Comments on the Applicant's Response to Relevant Representation from [REDACTED] of Foxley Road

Nurseries, Interested Party Reference Number: [REDACTED]

Drawing no.: RAC/10079/2B
Co-ordinate system: OSGB36 / British National Grid
Scale: 1:25000 @ A3

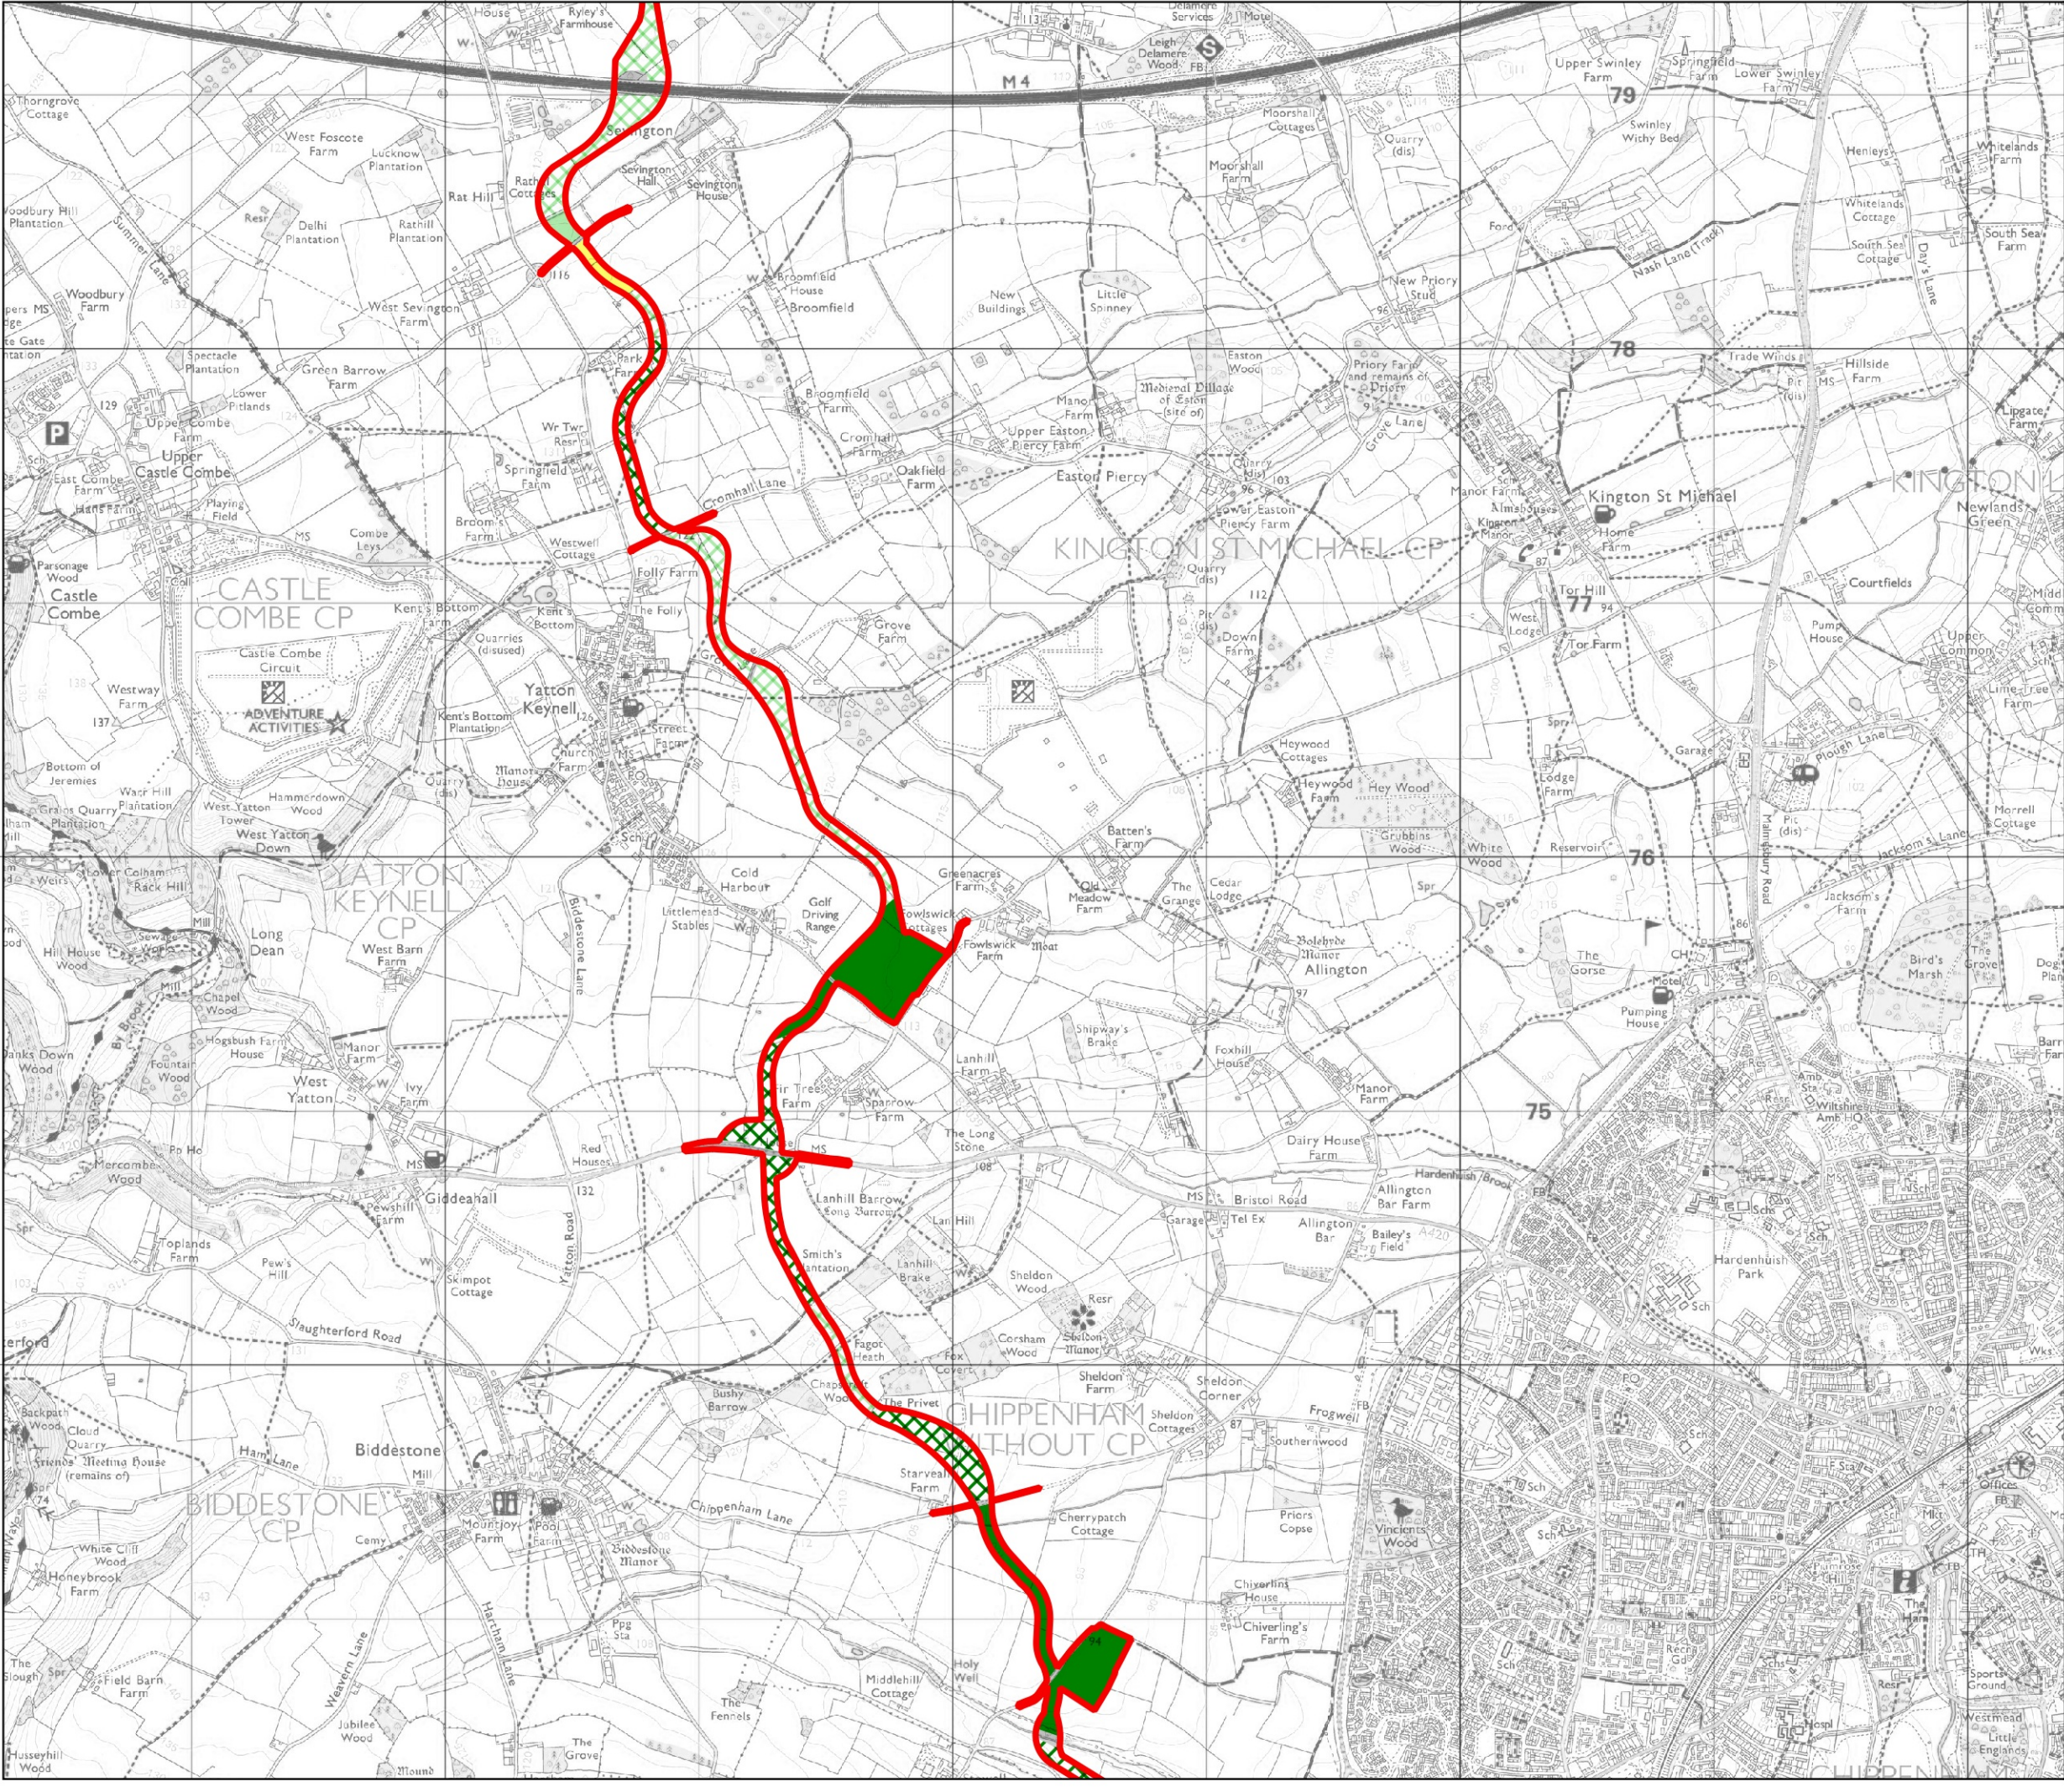
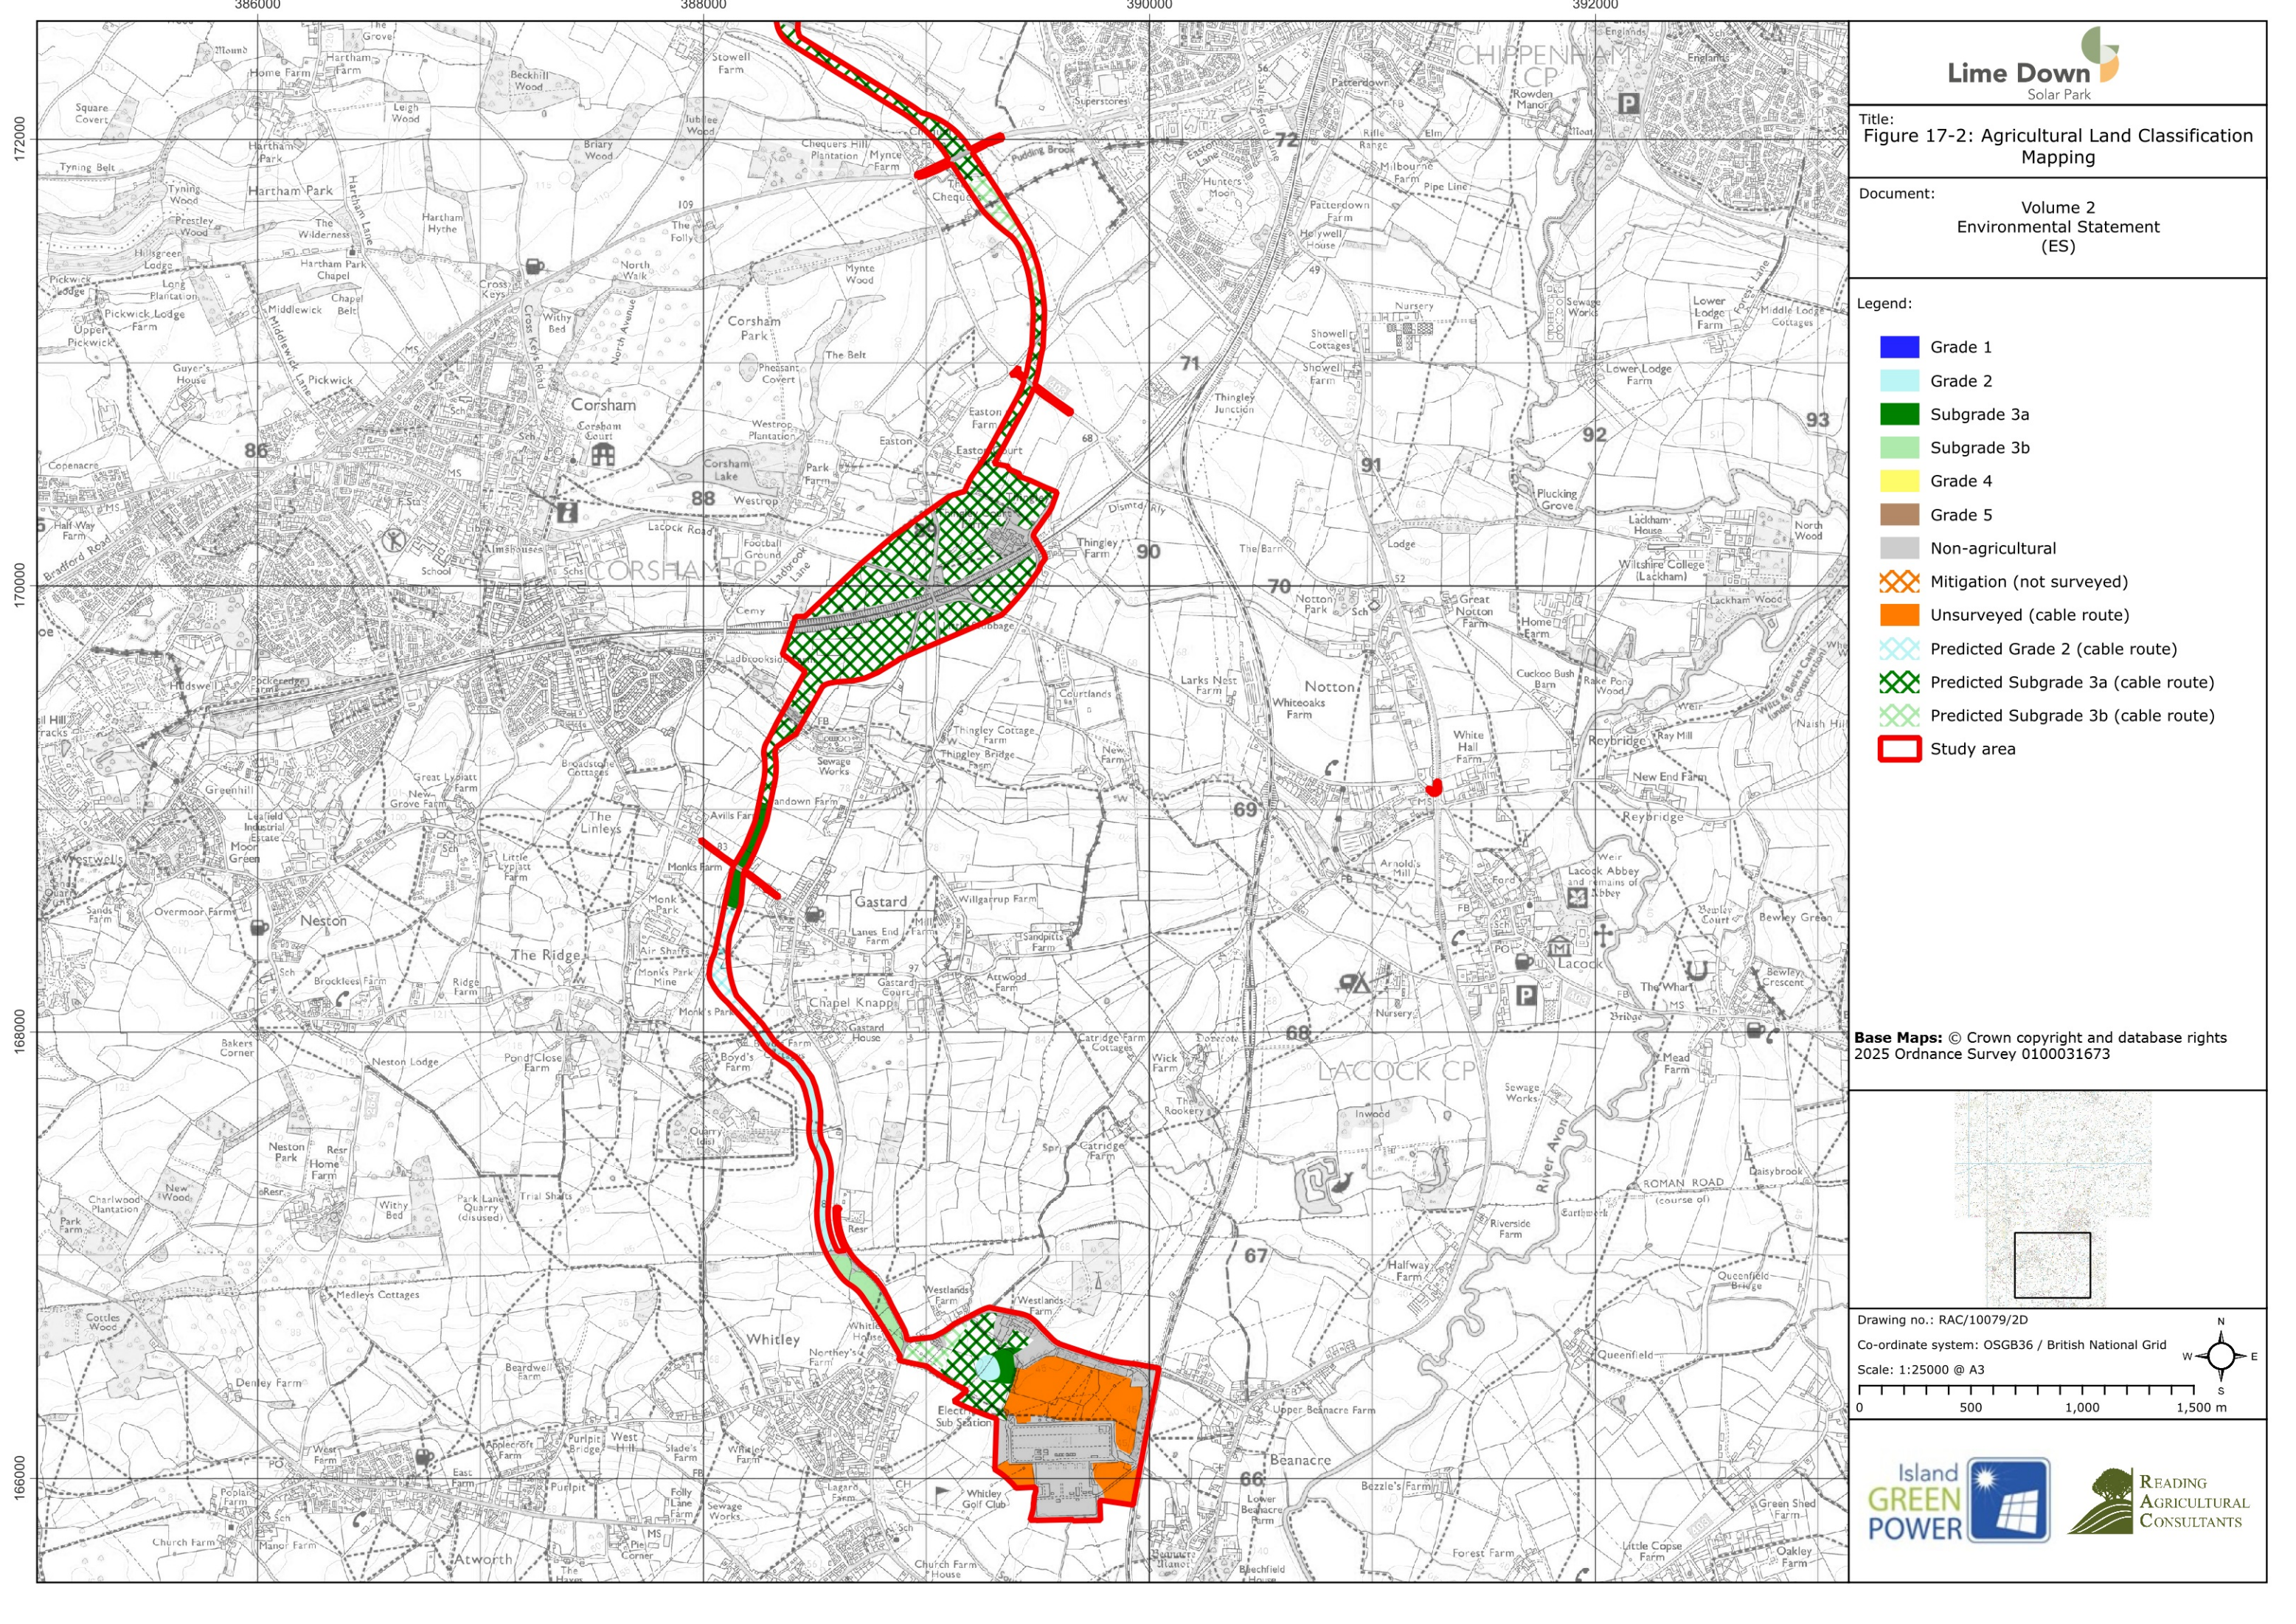
The Applicant's assessment of the proposed land identifies that the majority of agricultural land affected is not Best and Most Versatile (BMV) land, comprising predominantly Subgrade 3b and Grade 4 land, which is not considered high quality agricultural land in planning terms, however local farmers including tenant farmers have grown food and earned a living from that land over many centuries. At the end of the lifetime of the scheme, disposal of the panels, concrete, etc will have a huge environmental impact and will involve another extended period of HGV movements. Severe compaction of the ground will be extremely difficult to remedy. It is hard to believe that the entire area will be reinstated as farmland.
